CITY OF ALBUQUERQUE

Re: Eagle Ranch NMDMV
9651 Eagle Ranch Rd NW
30-Day Temporary Certificate of Occupancy- Transportation Development
Transportation Development Final Inspection
Architect's Stamp dated 06-07-17 (B13-D002C)
Certification dated 12-13-17

SHEET NUMBER

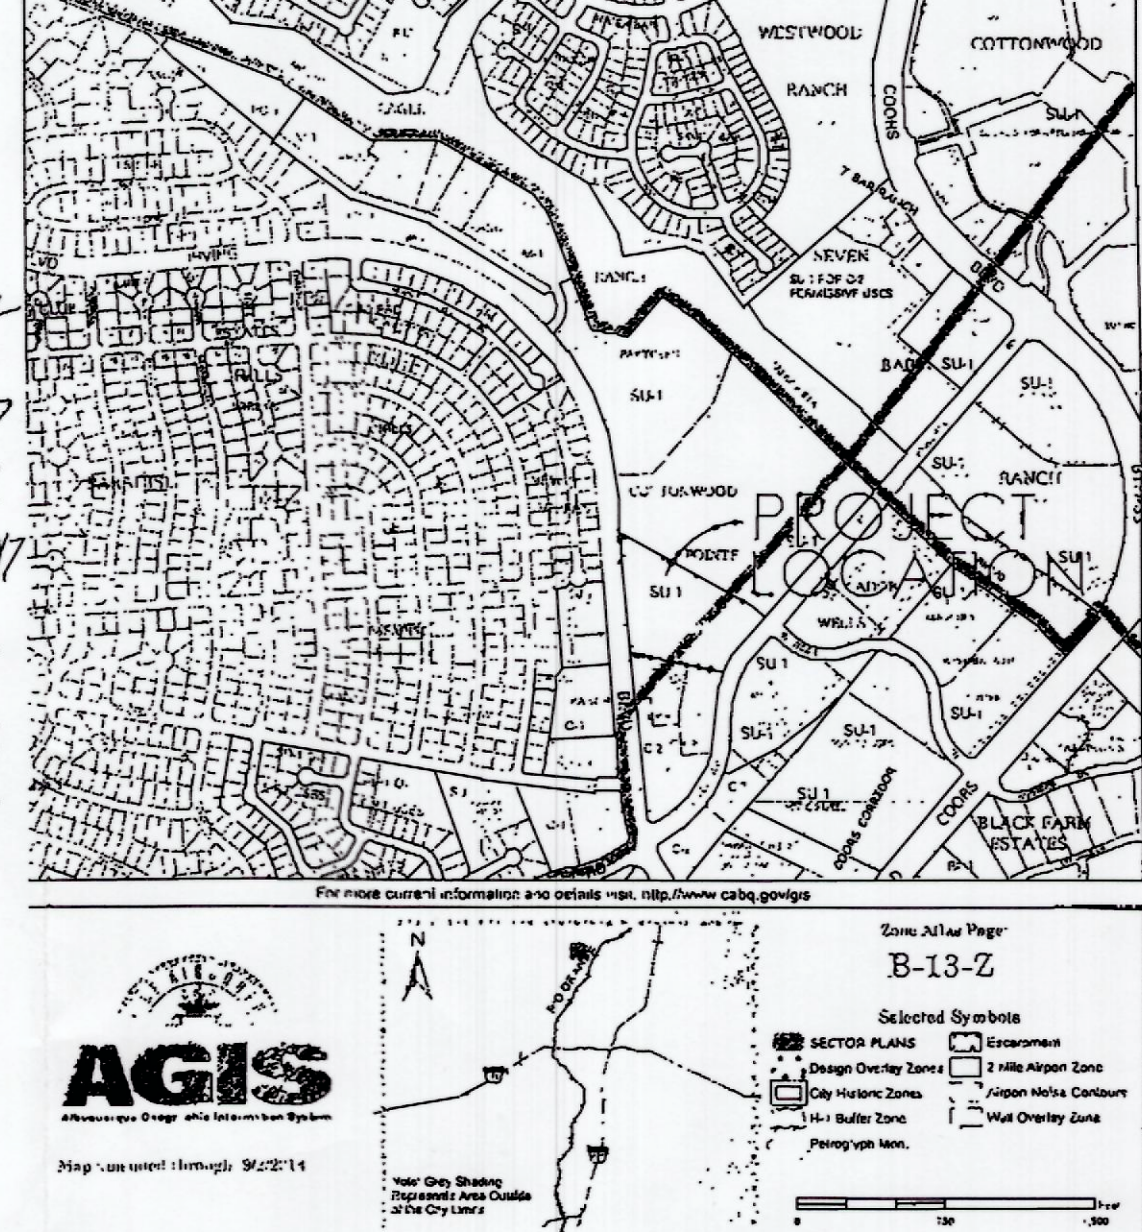
1. The ADA access aisles shall have the words **"NO PARKING"** in capital letters, each of which shall be at least one foot high and at least two inches wide, placed at the rear of the parking space so as to be close to where an adjacent vehicle's rear tire would be placed. (66-1-4.1.B NMSA 1978)
2. Motorcycle parking spaces must be designated by its own conspicuously posted upright sign, either free-standing or wall mounted per the zoning code.
3. One-way vehicular paths require pavement directional signage and a posted **"Do Not Enter"** sign at the point of egress.
4. ADA ramps cannot extend into the access aisles of the accessible parking spots.
5. The site plan should indicate that the road around the back of the site is base course and if it will be built in a later phase.
